M5 Junction 10 Improvements Scheme

Change Application 2 Environmental Statement Addendum TR010063 – APP 10.23

DCO Change Application Environmental Statement Addendum

Drawing Title
**STRUCTURAL DETAILS
NEW WEST CHELTENHAM LINK ROAD
RIVER CHELT BRIDGE
SHEET 4 OF 12**

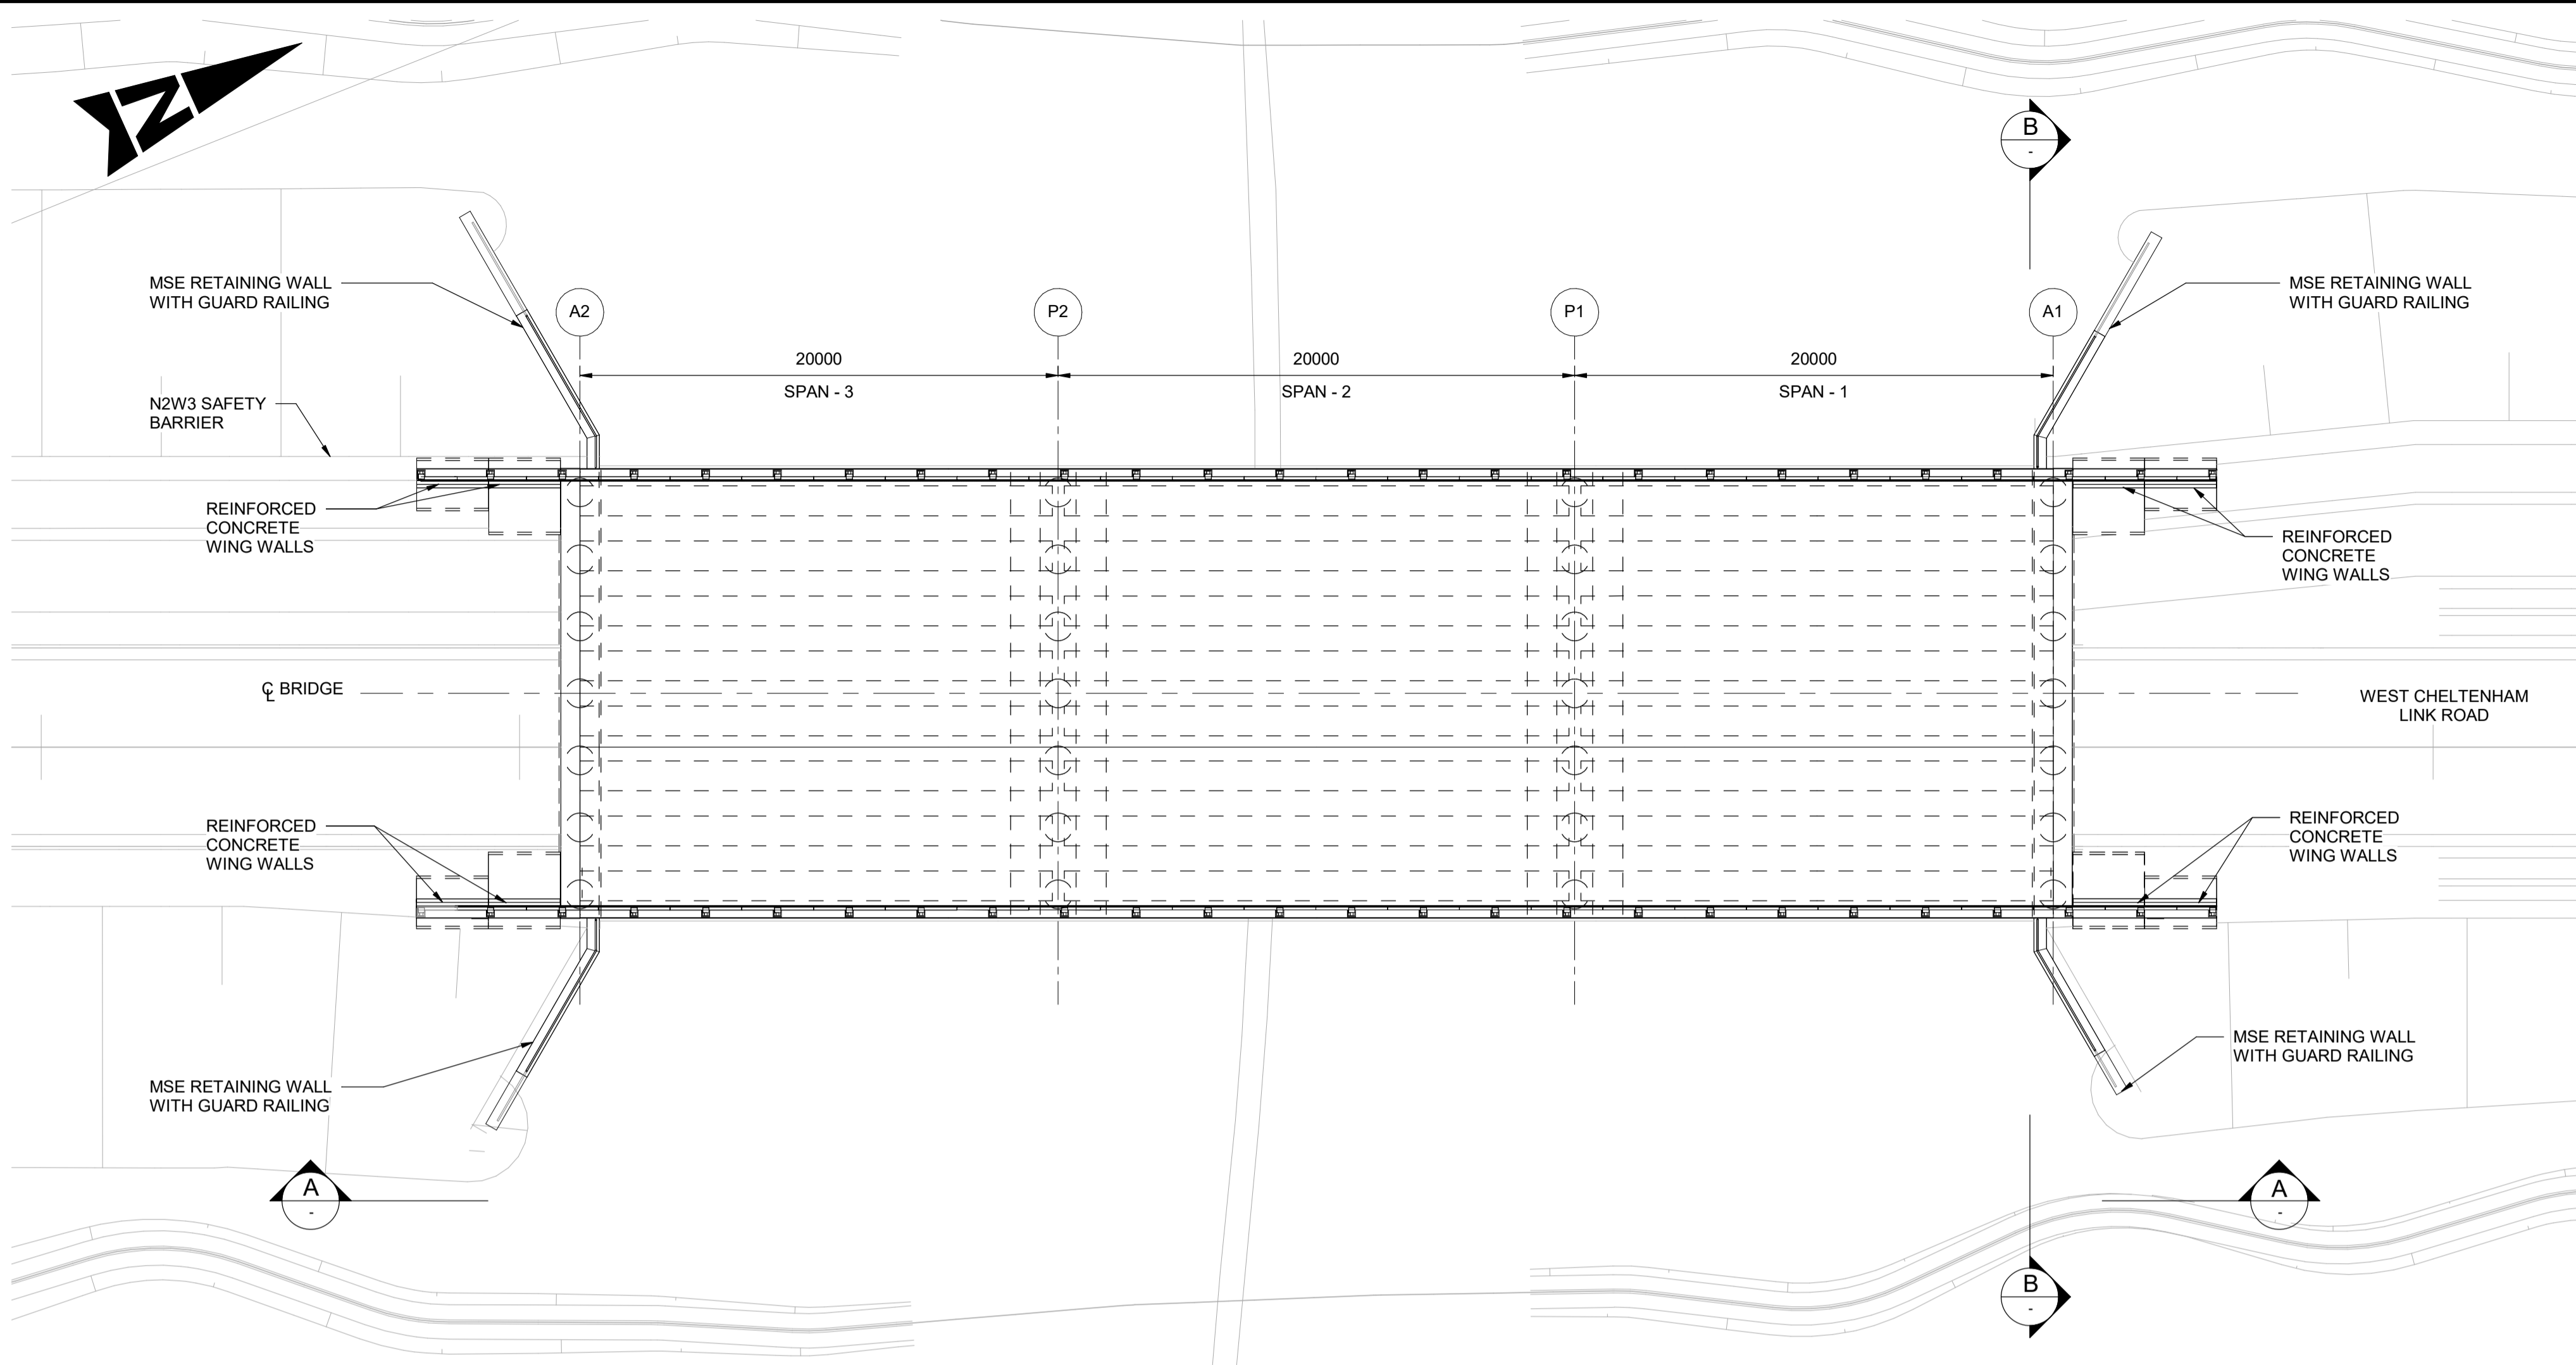
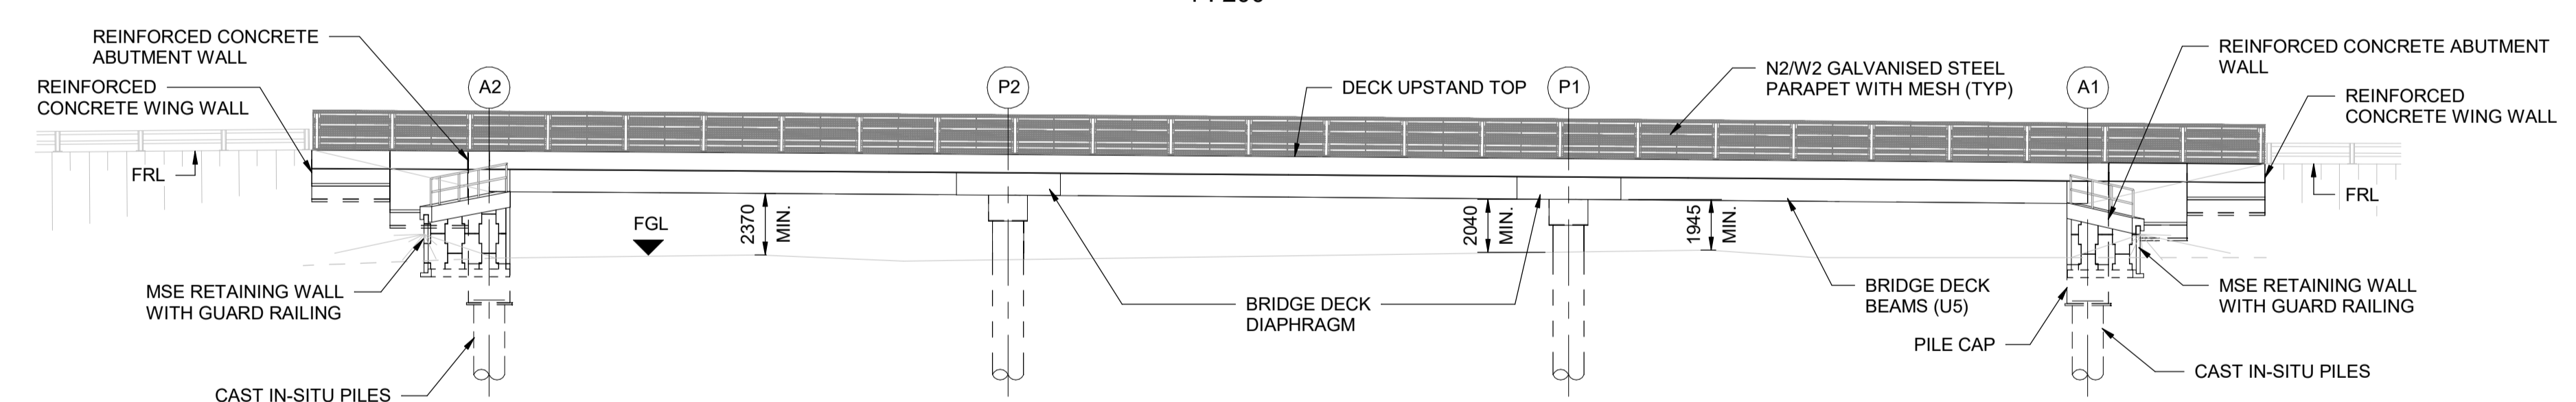
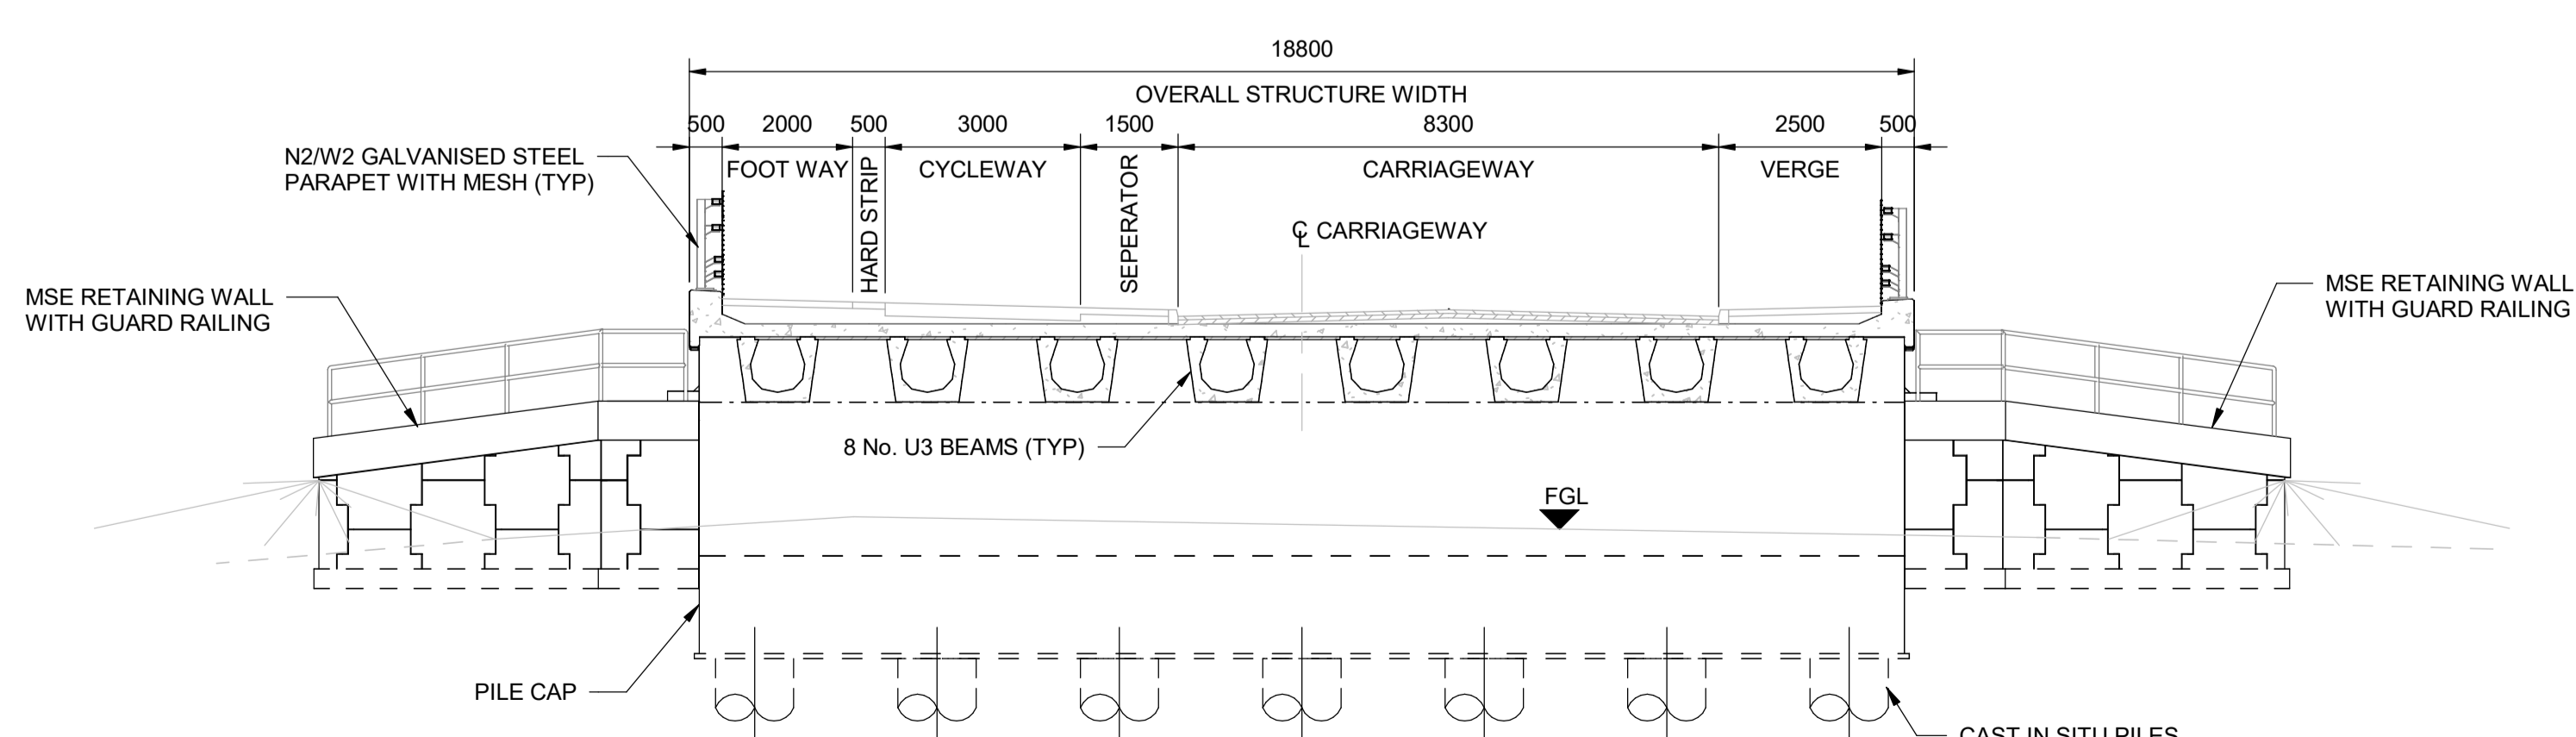
- 2.4.1. In the Scheme submitted as part of the DCO application the River Chelt bridge is a skewed structure with reinforced earth wing walls and a skewed span of 26.38m. The Scheme also includes some reprofiling of the existing riverbank to reduce the risk of erosion and create more natural channel profiles. The change is to utilise the requirement for the reprofiling works to straighten the river under the Link Road River Chelt Bridge (to run perpendicular to the Link Road), thereby allowing the installation of a straight (rather than skewed) structure with abutments running perpendicular to the Link Road. To mitigate for the section of straightened channel, the River Chelt will be realigned to exaggerate the natural meandering upstream and downstream of the River Chelt bridge. The pools and riffles between meanders described in the ES will be retained. The ES Scheme mitigation, including enhancements to riparian vegetation, bank reprofiling to create more natural profiles and installation of in channel enhancements, will also be further developed within the Order limits which are extended 160m upstream and 100m downstream of the River Chelt Link Road bridge. A constructability review by the Applicant has identified the need for a temporary diversion channel to allow for the construction of the River Chelt reprofiling and mitigation associated with the Link Road River Chelt bridge. The requirement for the temporary diversion was not assessed as a construction activity within the ES. A temporary diversion would also be required for the change but would be no different from the diversion identified from the constructability review for the Scheme. To ensure any impacts from the temporary diversion are suitably mitigated, the Register of Environmental Actions and Commitments (REAC) [REP4-018] will be updated (B23, WE1 and WE3) as this was not included in the ES. The updated details are provided by the Applicant in the 'Summary of Changes to the Register of Environmental Actions and Commitments' document [APP 10.26], submitted as part of the Change application 2.

- 2.4.2. The change is shown in Structural Details – New West Cheltenham Link Road River Chelt Bridge Sheet 4 of 12 and Environmental Master Plan Sheet 15 of 16.

- 2.4.3. The change will improve constructability of the River Chelt Bridge, thereby reducing risk in the construction programme, and will improve the long-term performance of the River Chelt Bridge structure.
